Mrs. Brenda Vandamme
Partway House
Swalcliffe,
OXON
OX 15 5HA

Ref : Planning Application- SPE 20/02956/F

As owner and occupant of the neighbouring property, Partway House, I write in connection with the proposal from Swalcliffe Park Equestrian Ltd to construct three large, permanent horse jump structures (Cherwell District Council Reference 20/02956/F). All three constitute s55 development and, having reviewed the proposal documents and relevant policy, along with revisiting case history,

0 2 4 6 8 10 20 30M 1:400
 0 1 2 3 4 5 10 15M 1:200
 PAPER SIZE A3
 SWANCLIFFE PARK EQUESTRIAN DWG KSA1

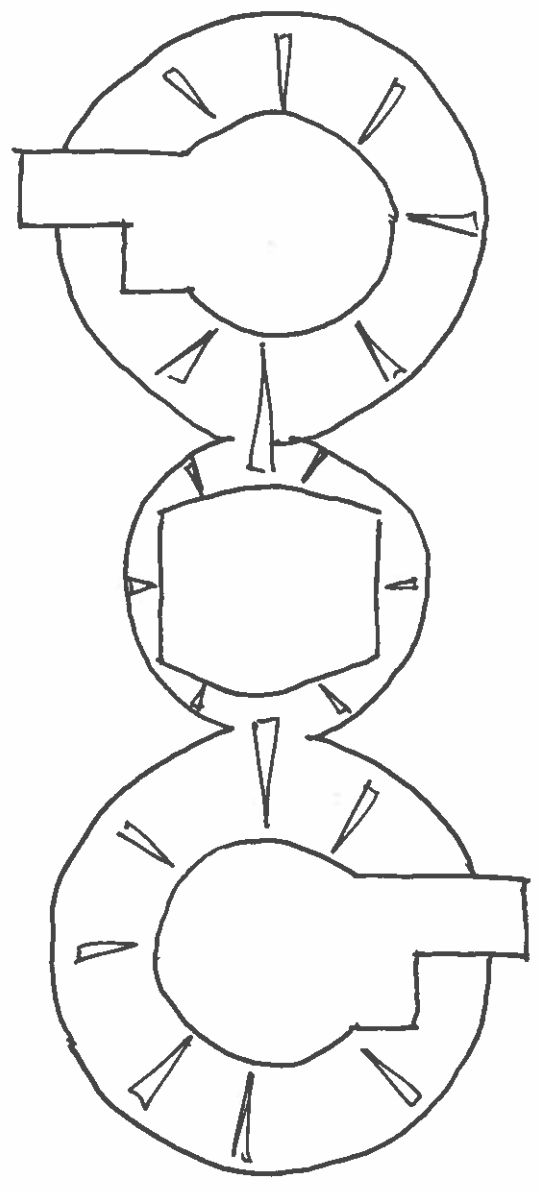
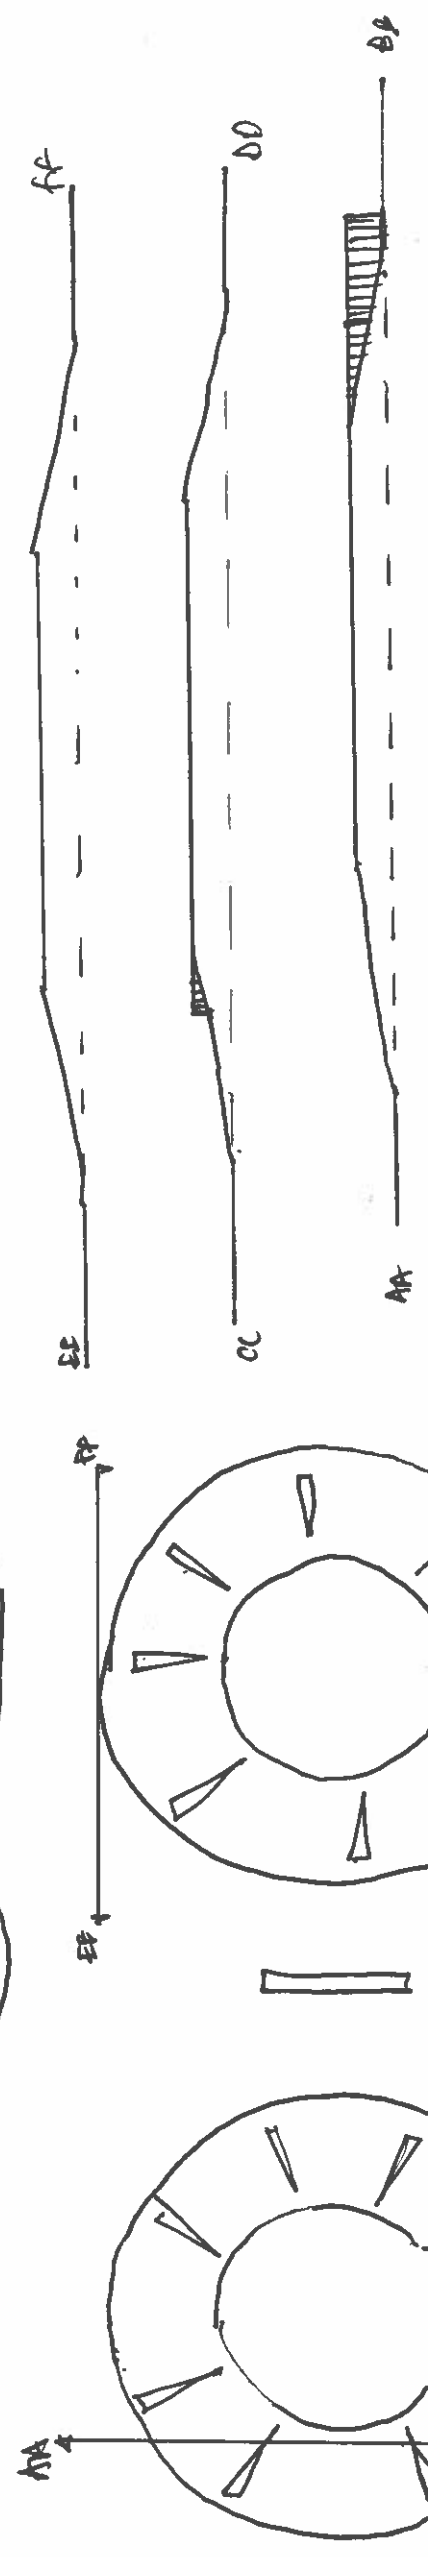
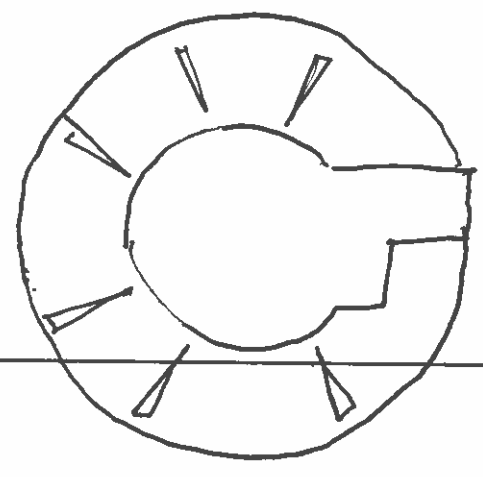
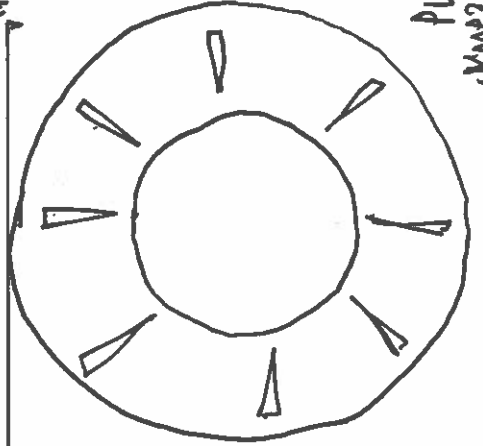
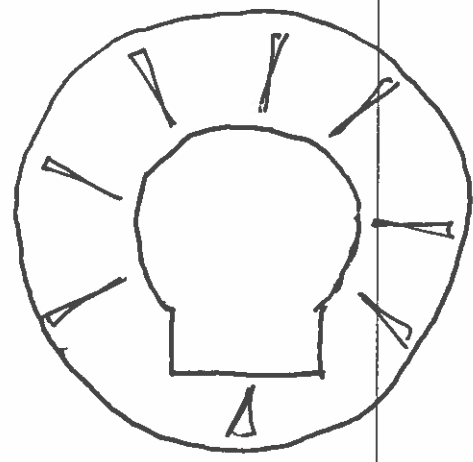
Finally, we are concerned that the drawings submitted are not representative of the development, for example the sketches contained in the document marked as “area of Proposed Engineering Works” show a series of features which are not shown on the site plan. It is therefore impossible to imagine what these features will look like or indeed the scale of these once they are installed.

In the perhaps unlikely event that you are minded to approve the proposed development it will be important to have these checked, based upon a Topographic Survey. It would also be helpful to have sections provided showing the relation between the height of the structures and a jumping horse and rider against the height of existing hedges.
